THE HILLS SHIRE COUNCIL

13 April 2018

Council received notification on 24 January 2018 of a Modification request to modify State Significant Development 6074 for the Norwest Private Hospital Expansion at 7-11 Norbrik Drive Bella Vista.

SECTION A-A

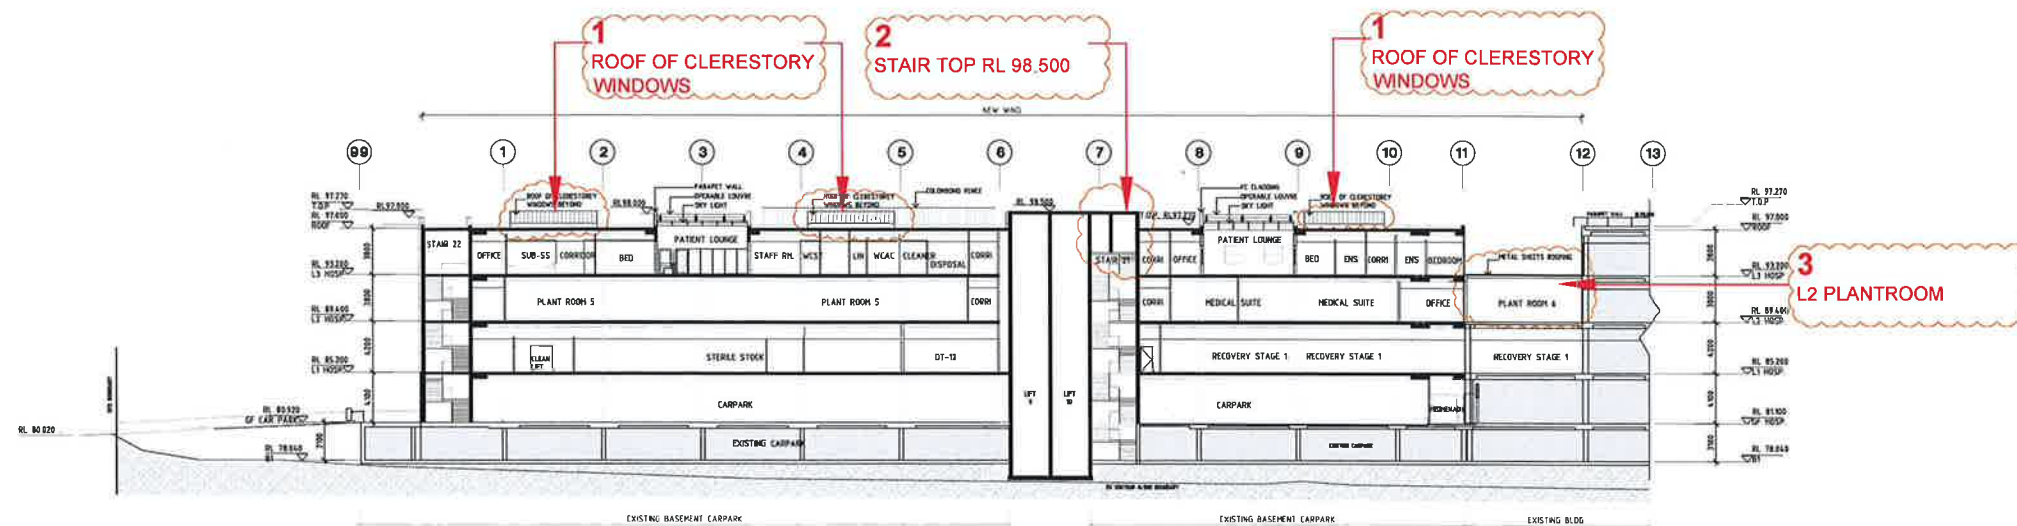
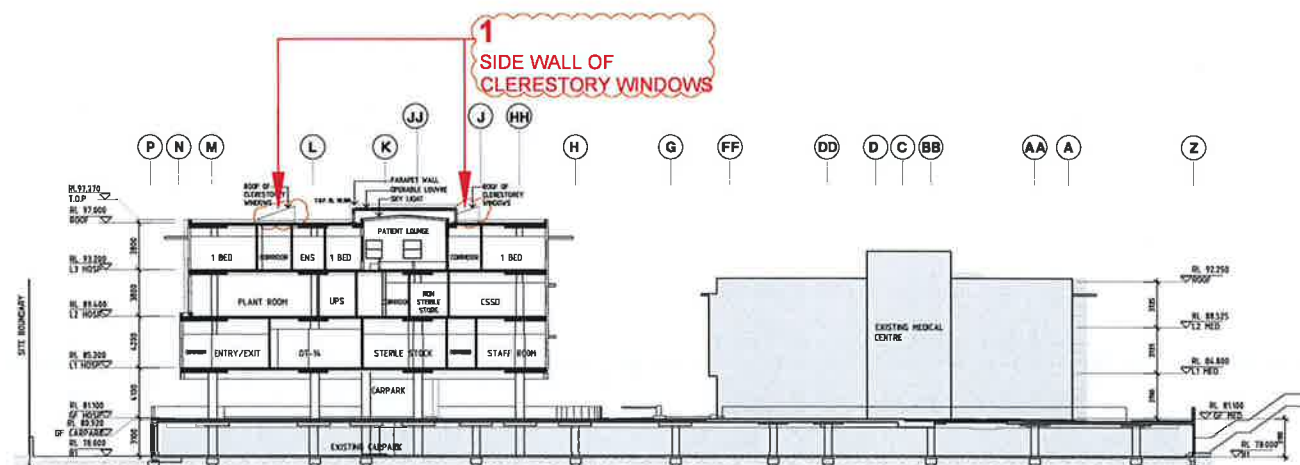
Additionally, Section A depicts the topography and visual relationship between Bella Vista Farm and Pearce Family Cemetery and Section C depicts the topography and visual relationship between the base of bunya pines and former alignment of Old Windsor Road. Neither section depicts the proposed height of Norwest Private Hospital and should be amended accordingly for full consideration of visual impact.

HEIGHT PLANE PHOTOMONTAGES

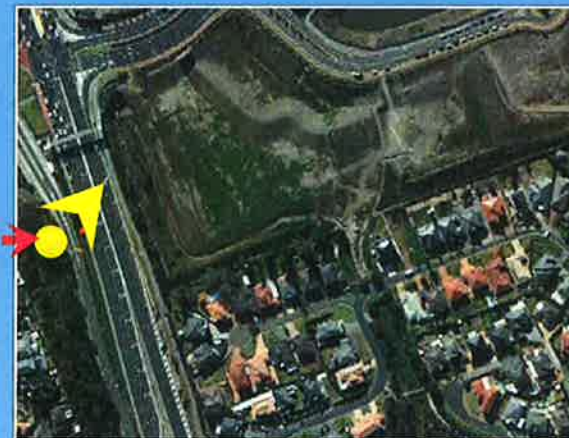
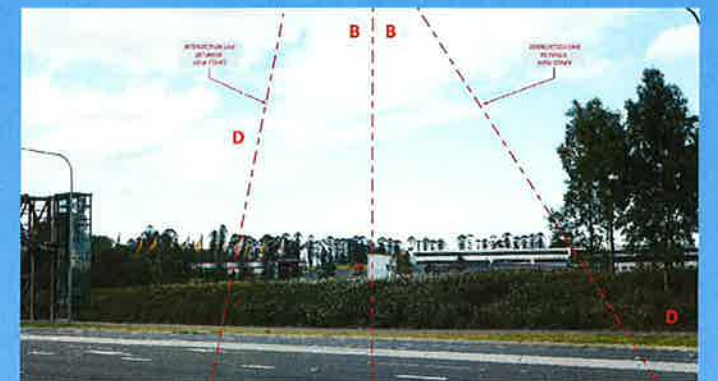
From the photomontage submitted with the application, it is indeterminable whether the expansion exceeds the dotted line referred to in the DCP montages as the dotted line has not been indicated on the photos in relation to the proposed built form outcome. While sightlines to the Pearce Family Cemetery and Old Windsor Road appear to be maintained from this perspective, it is recommended that the photomontage be amended to reflect the development's relationship with the dotted line so that a full assessment of the impact on views and vistas can be made.

This image along with other montages submitted, depict building forms that are not able to be developed under the current planning framework. As a result the impact of the level 4 expansion of Norwest Private Hospital on views to Bella Vista Farm Park cannot be fully assessed. It is recommended that the photomontage be amended to include only development that has been approved by Council or is part of the proposed modified concept. This includes amending montages 6-8, 9A, 11, 12 and 12A as the development shown in these montages are not subject to the current application and make it difficult to isolate and assess the impacts of the built form under consideration in the subject application.
